Approval of details reserved by condition imposed under ref BN/50/20/PL relating to Condition Nos 5 - mitigation method statement, 6 - archaeology, 7 - piling risk assessment & method statement, 8 - Construction & Environmental Management Plan, 9 - foul drainage, 10 - surface water drainage, 11 - maintenance & management of surface water drainage, 13 - pre-commencement site meeting, 15 - odour assessment or evidence that livery has ceased, 16 - soil resource plan, 17 - landscaping, 18 - screen walls & fences, 19 - elevation details of 2 proposed communal bin stores and 20 - colour schedule of materials & finishes.

Land Rear Of 1 Northfields Cottages Fontwell Avenue Eastergate PO20 3RX

Condition Number 17

Arun District Council have decided to **REFUSE details reserved by condition for the following reasons:**

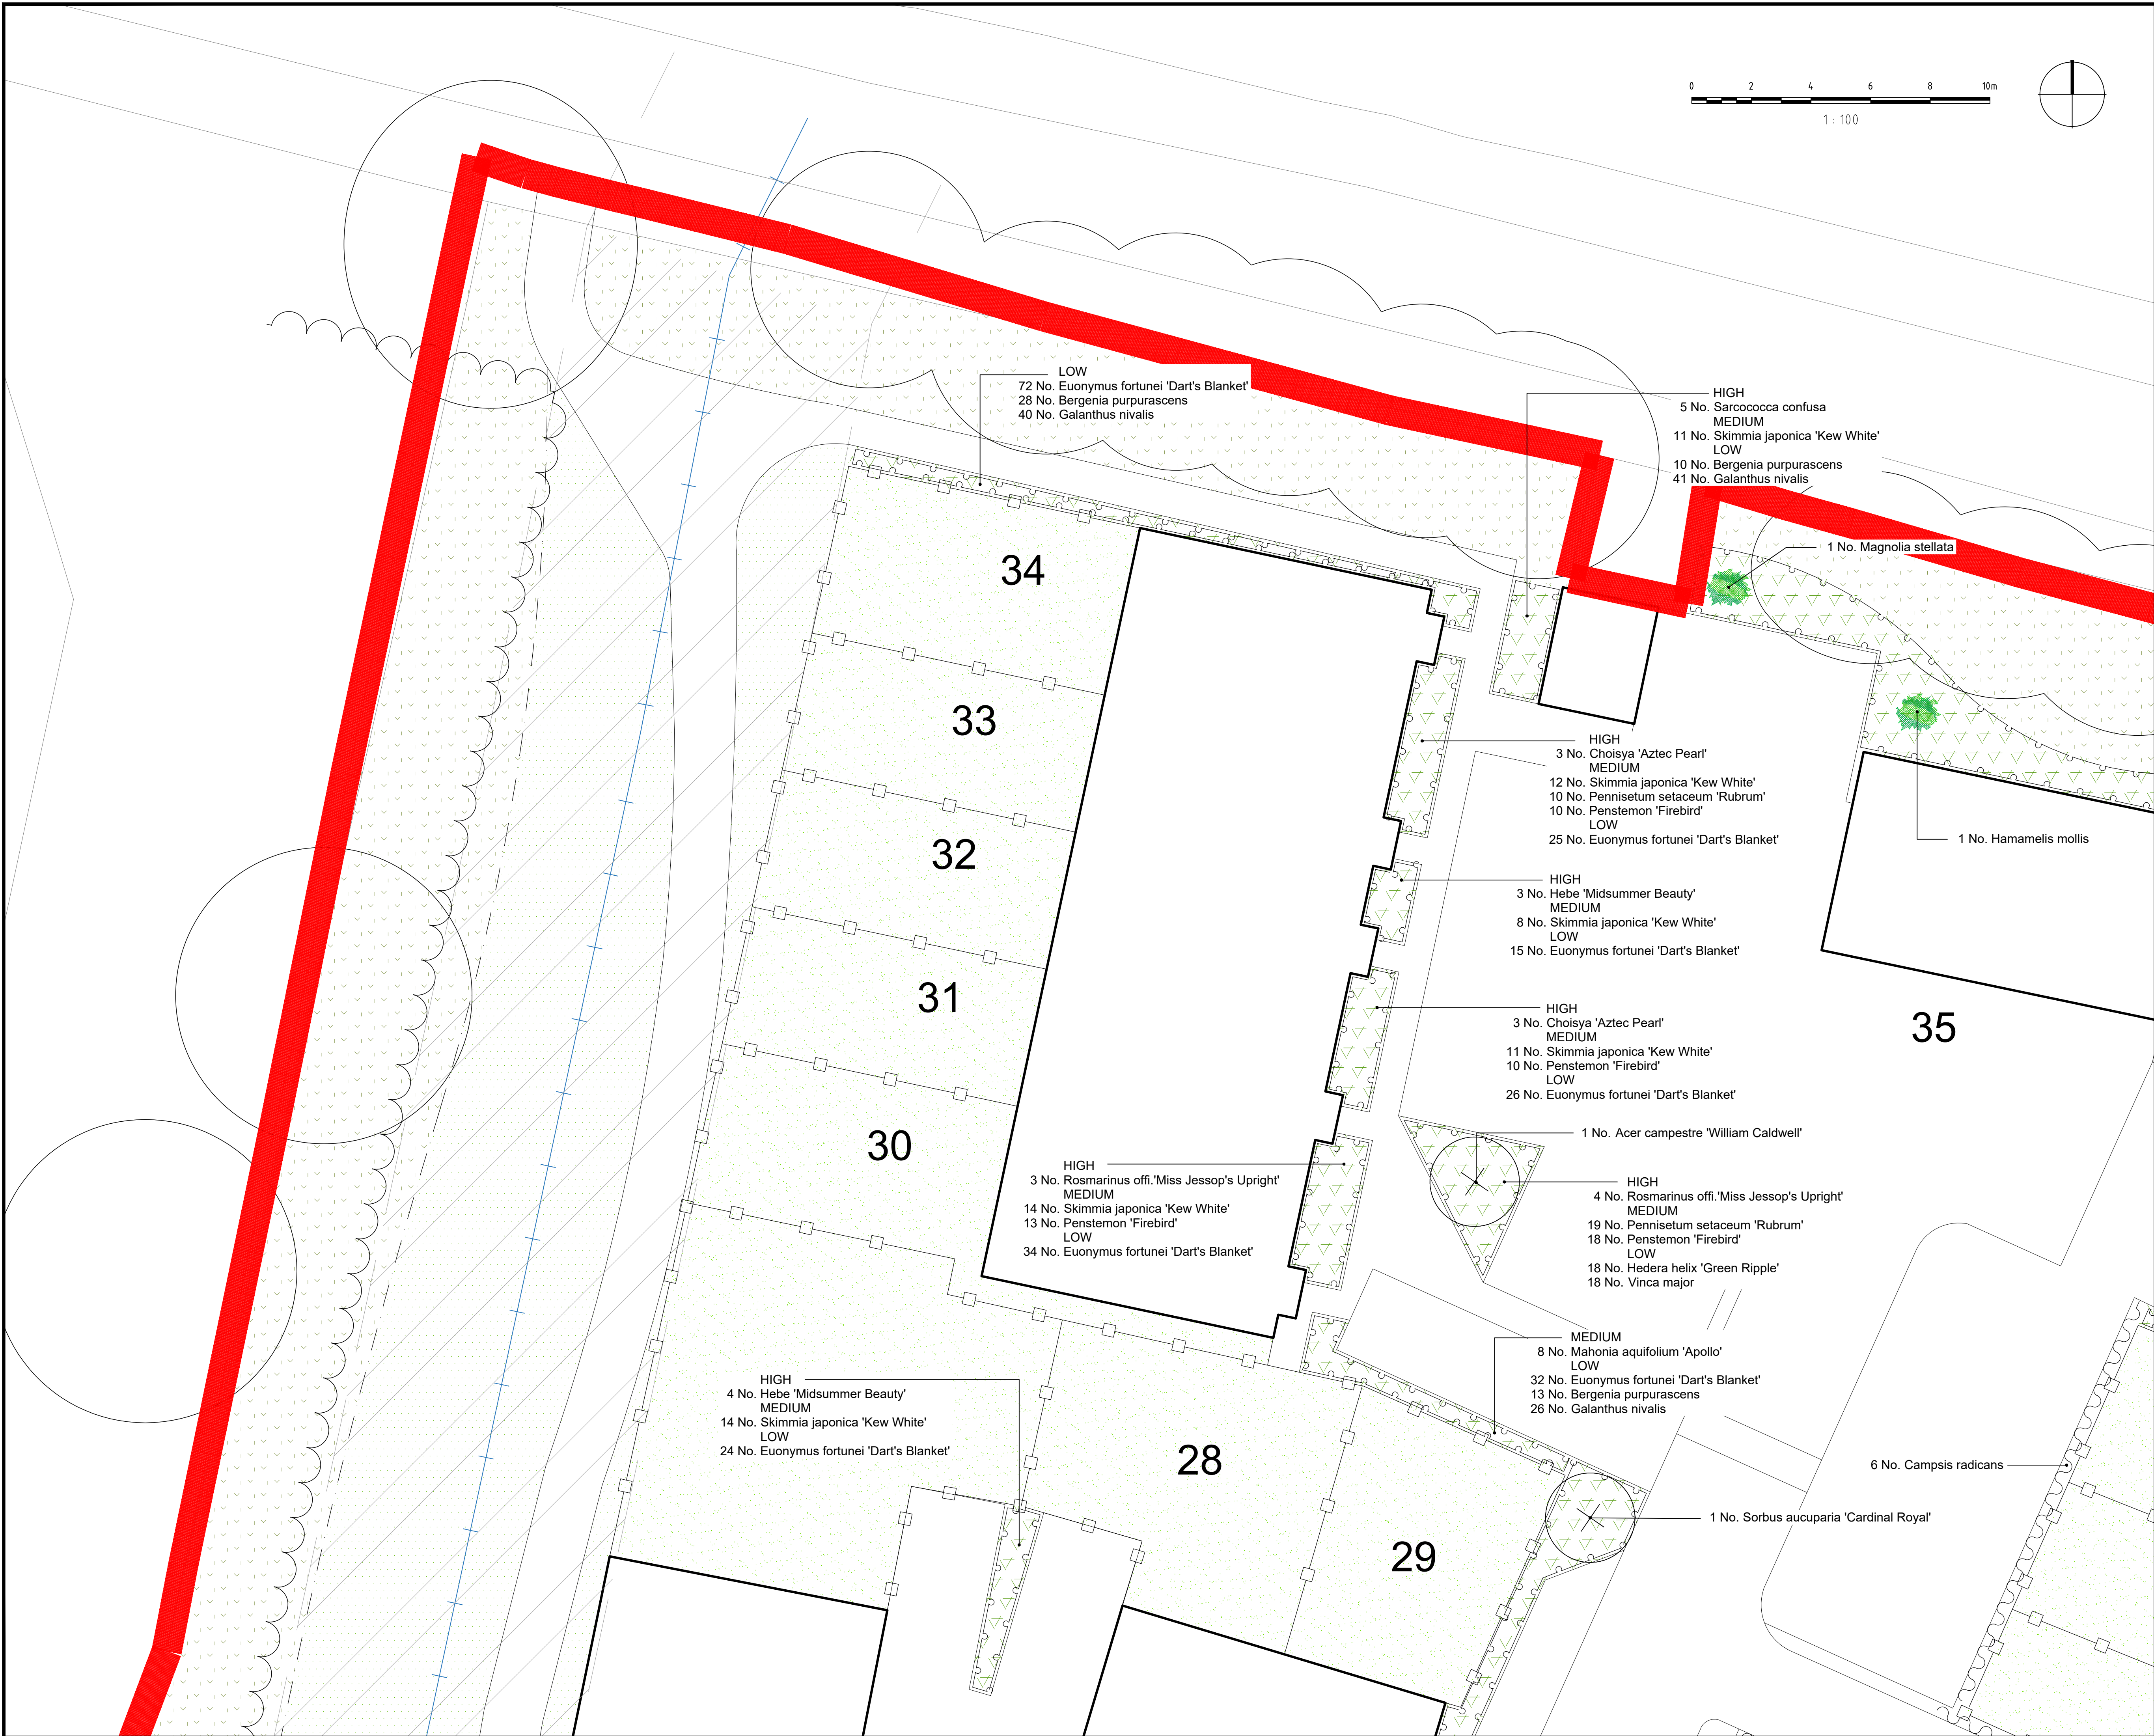
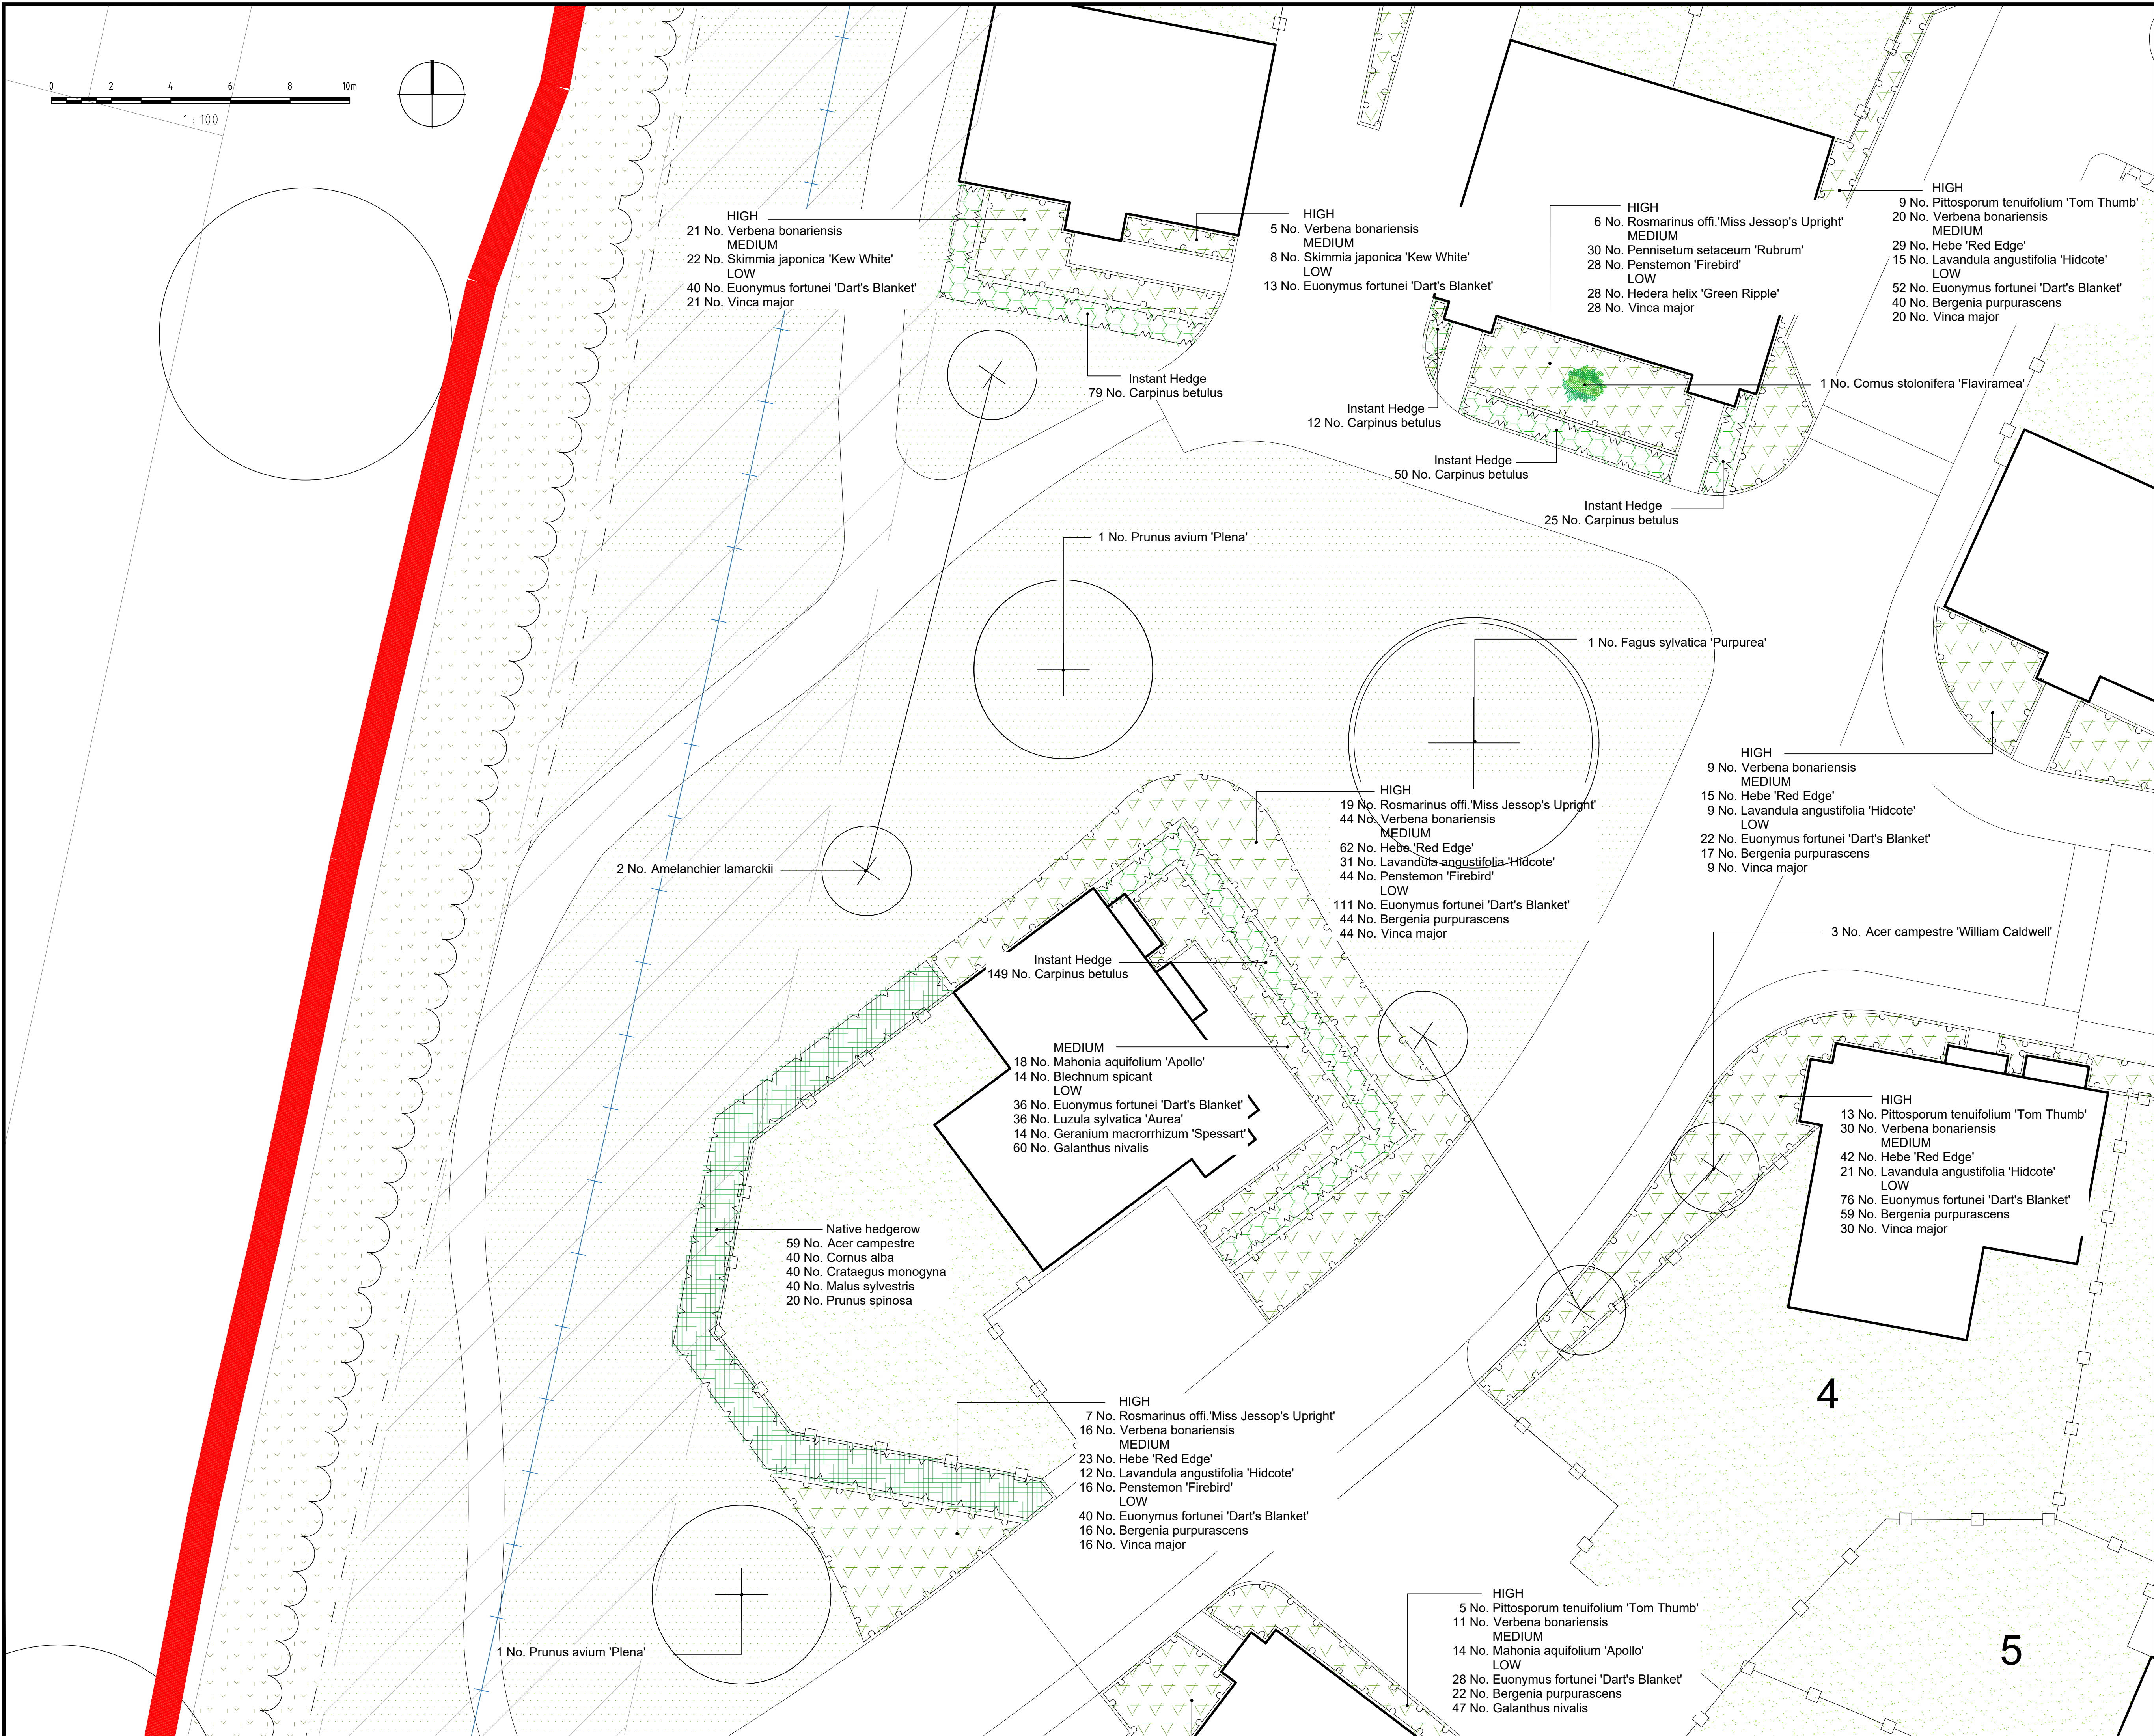
The Council's Landscape Officer has agreed the proposed landscaping scheme but comments that the drawings should be amended to show the previously agreed play provision of timber fitness items into the POS areas to the n/west area of the site.

It is also noted that the landscaping condition requires that at least 26 new native trees are provided to include specimens that will potentially grow to 10-15m high. Large trees are indicated but it is unclear what the height of these will be or how many of the tree species are native. The Landscaping drawing refers the reader to DD504L09 for the planting schedule/matrix and general specification but this does not appear to have been provided.

As such, it is not possible to discharge the condition at the current time and we would invite you to make a resubmission which (a) includes the timber fitness items on the drawings and (b) clearly demonstrates compliance with the specific requirements of the condition.
